Our Ref: M/21/22/NMA

Non-material amendment following grant of M/103/20/HH for the change roofing material on the northeast wing renovation from Corten steel to black coated corrugated steel; change the position of the stove and chimney in the northeast wing from the centre of the sitting room east wall to be in the northeastern corner of the room; Include an additional stove in the kitchen/dining area to the left of the french doors on the courtyard side; Reduce number of skylights in the kitchen on the west side from 3 to 2 and change the dimensions of all kitchen skylights from 150x150cm to be 134cm width x 140cm length; Reduce the length and position of the window running down the side of the front door in the courtyard from full length to more standard window dimensions, matching the guest bedroom length at the east end of the building.

Ancton Barn Ancton Lane Middleton-on-Sea PO22 6NJ

Drawing No Status Revision
203109/ 07 B

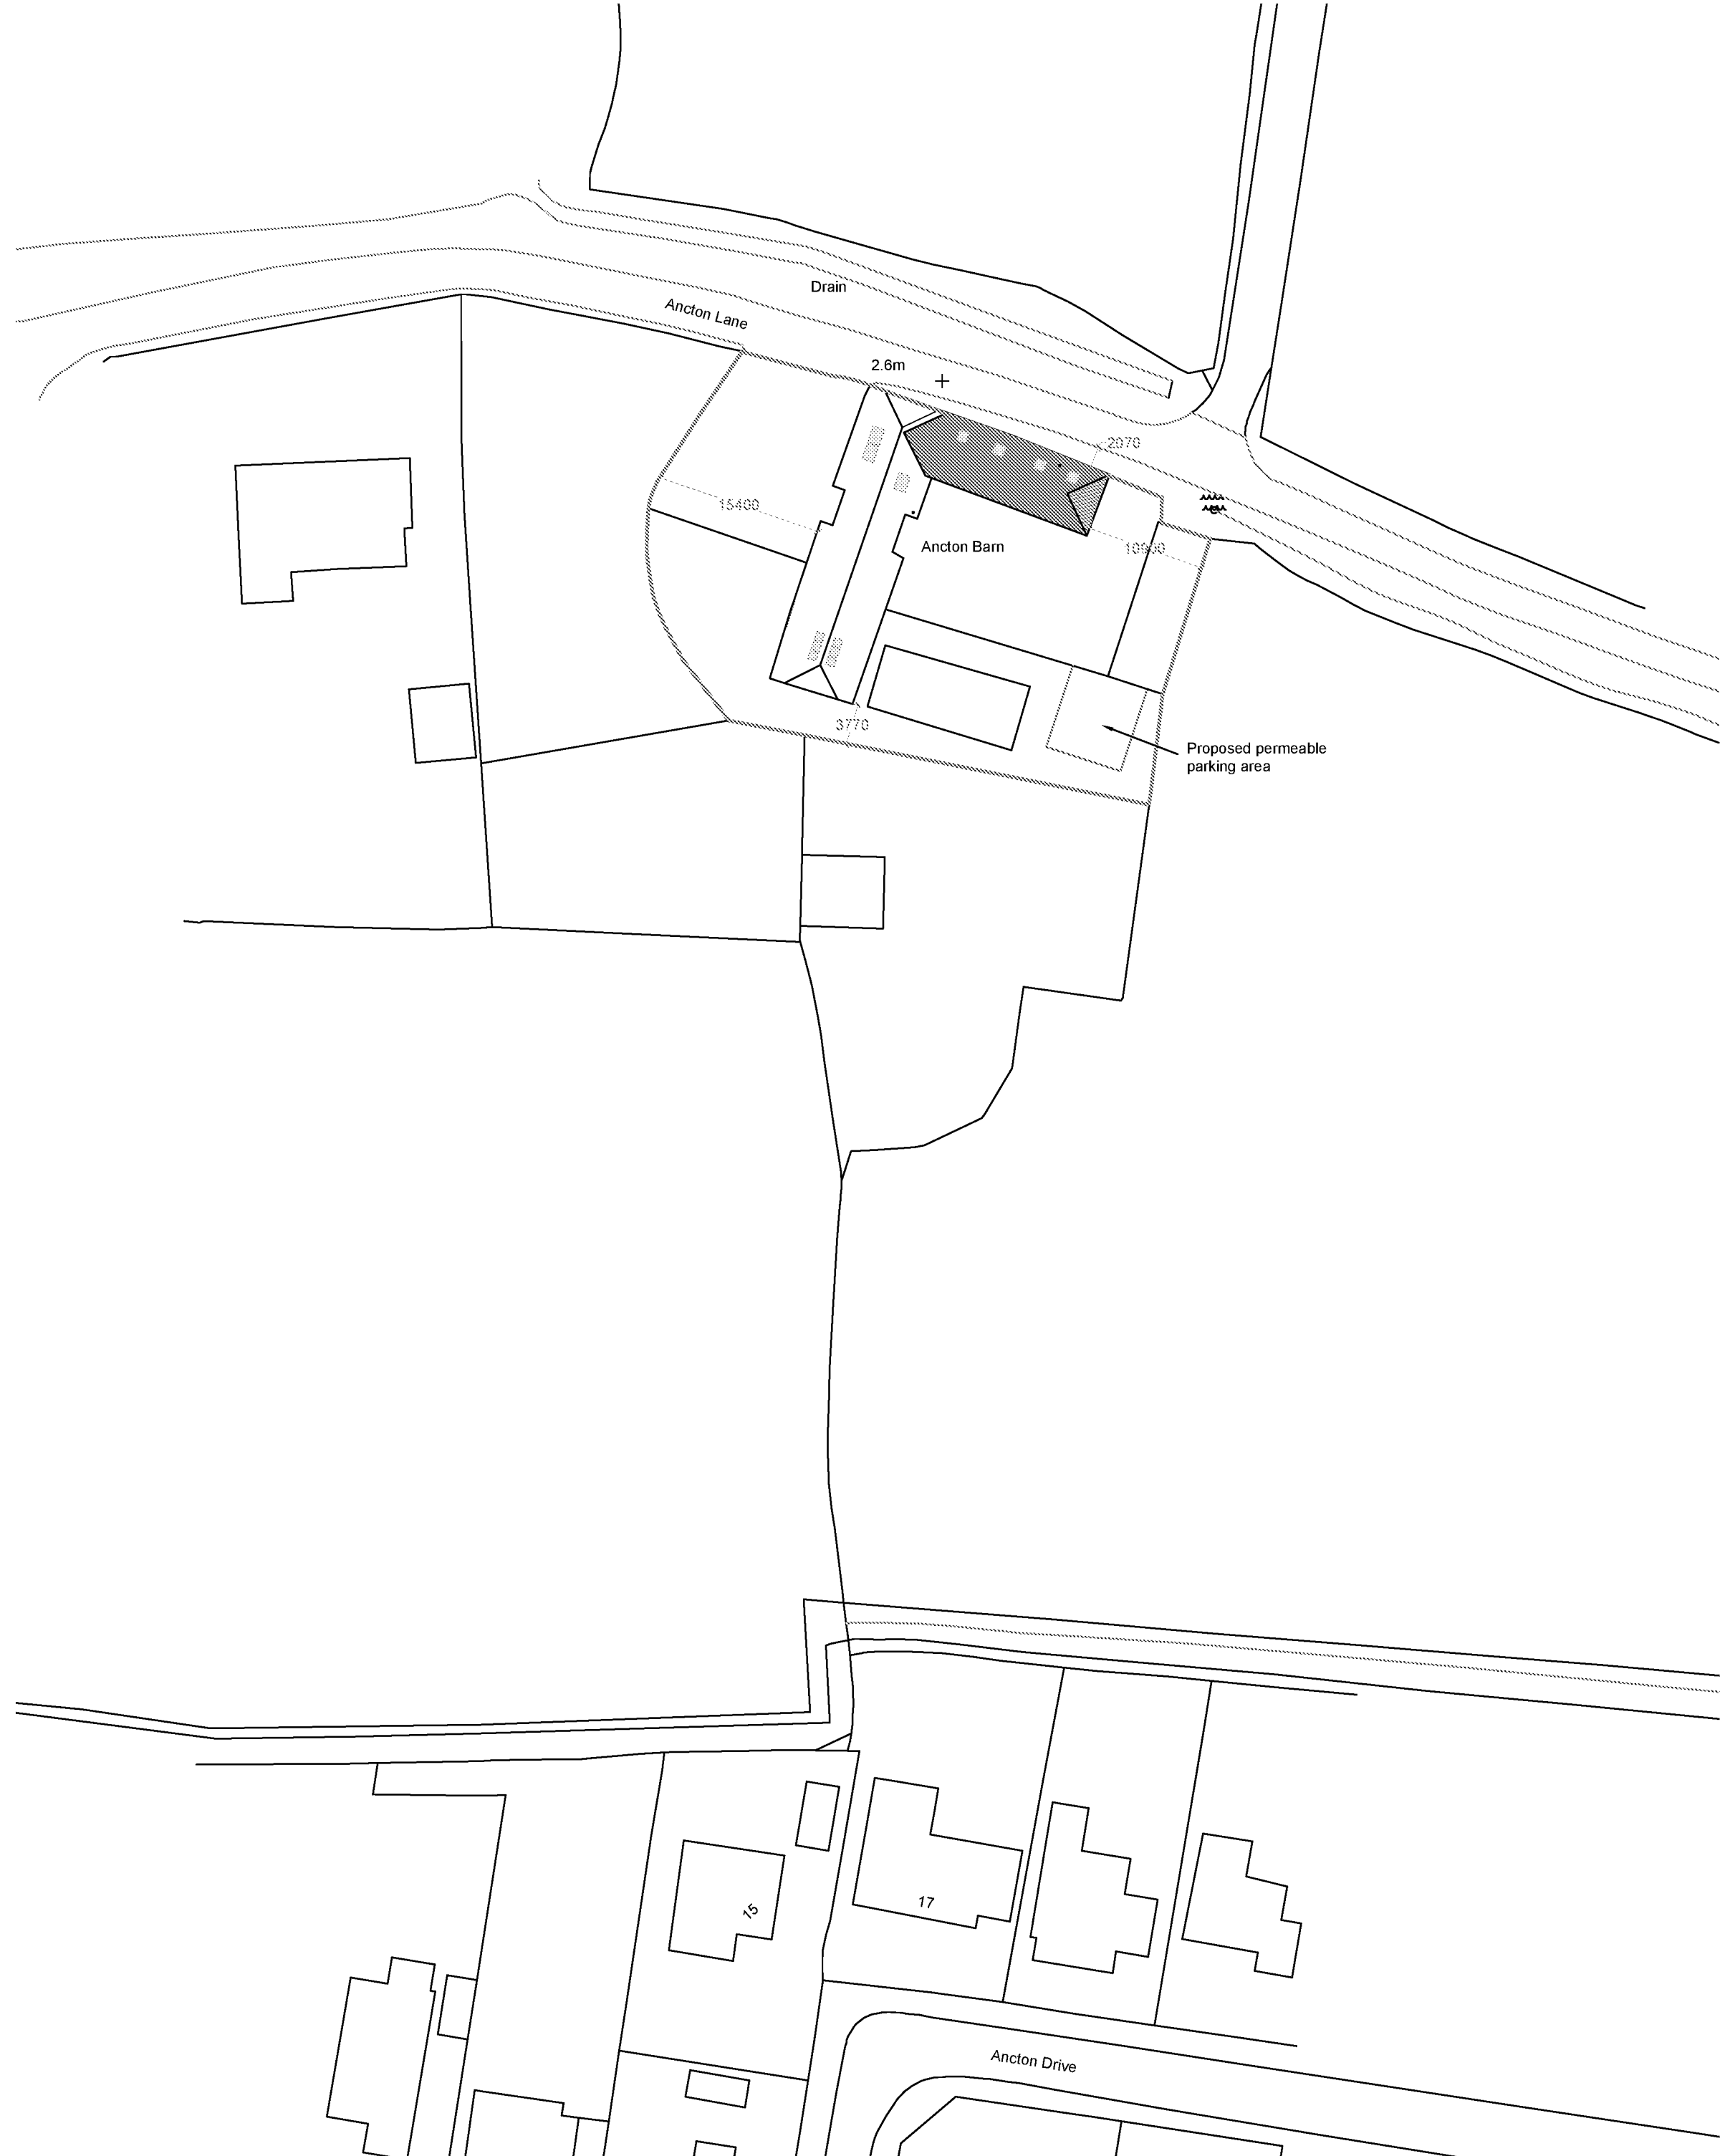
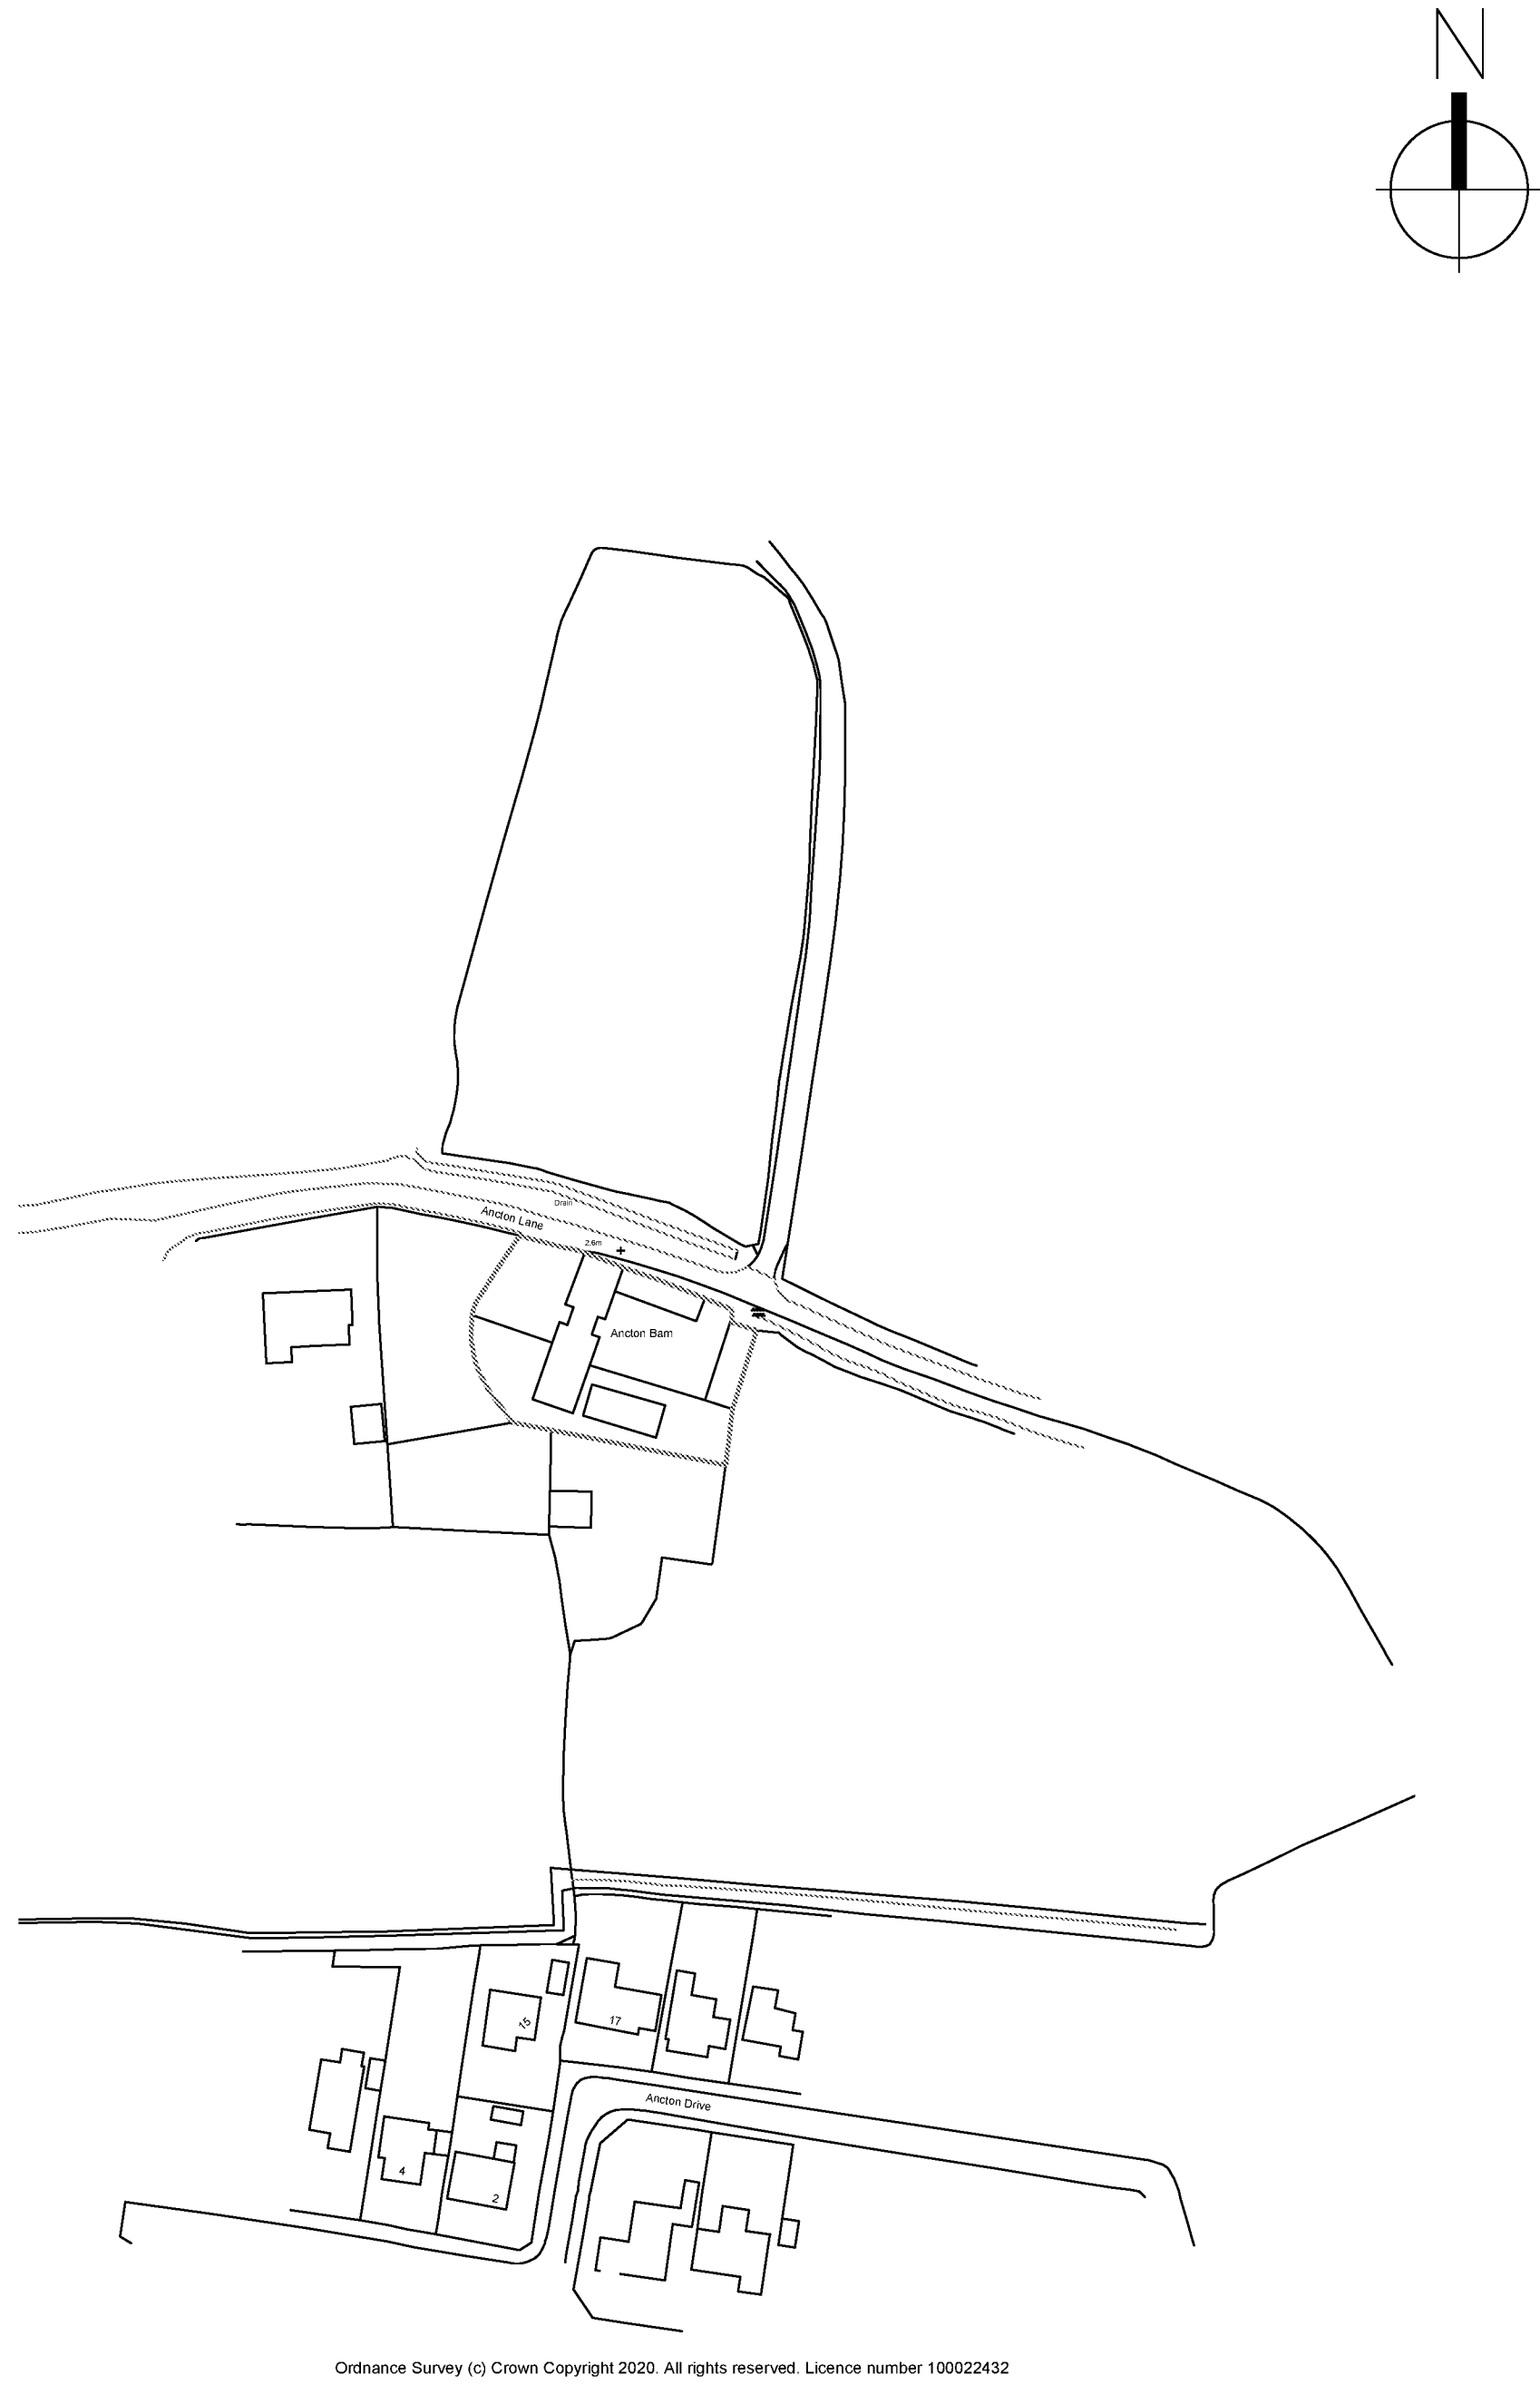
There would be further changes in fenestration arising from the revised internal layout; the number of skylights in the kitchen on the west side would be reduced from 3 to 2 and one of the two approved skylights on the eastern elevation would be removed due to insertion of a new chimney; the size of all kitchen skylights would be reduced from 150cmx150cm to 134cmx140cm; the length of the window running down the side of the front door in the courtyard would be reduced from full length to more standard window dimension and its position would be changed.

The proposed amendments would be minor, resulting in a reduction of fenestration and inclusion of an additional stove with chimney (which would protrude the ridge of the roof by 0.15m and would not result in an increase in footprint or scale of the approved dwelling. Therefore they can be considered as an NMA under section 96A of the Town and Country Planning Act 1990.

Please note that the drawing 203109/04 Rev B replaces the originally approved drawing 203109/04, the drawing 203109/05 Rev B replaces originally approved drawings 203109/05, the drawing 203109/06 Rev B replaces the drawing 203109/06 and the drawing 203109/07 Rev A replaces the drawing 203109/07 Rev B.
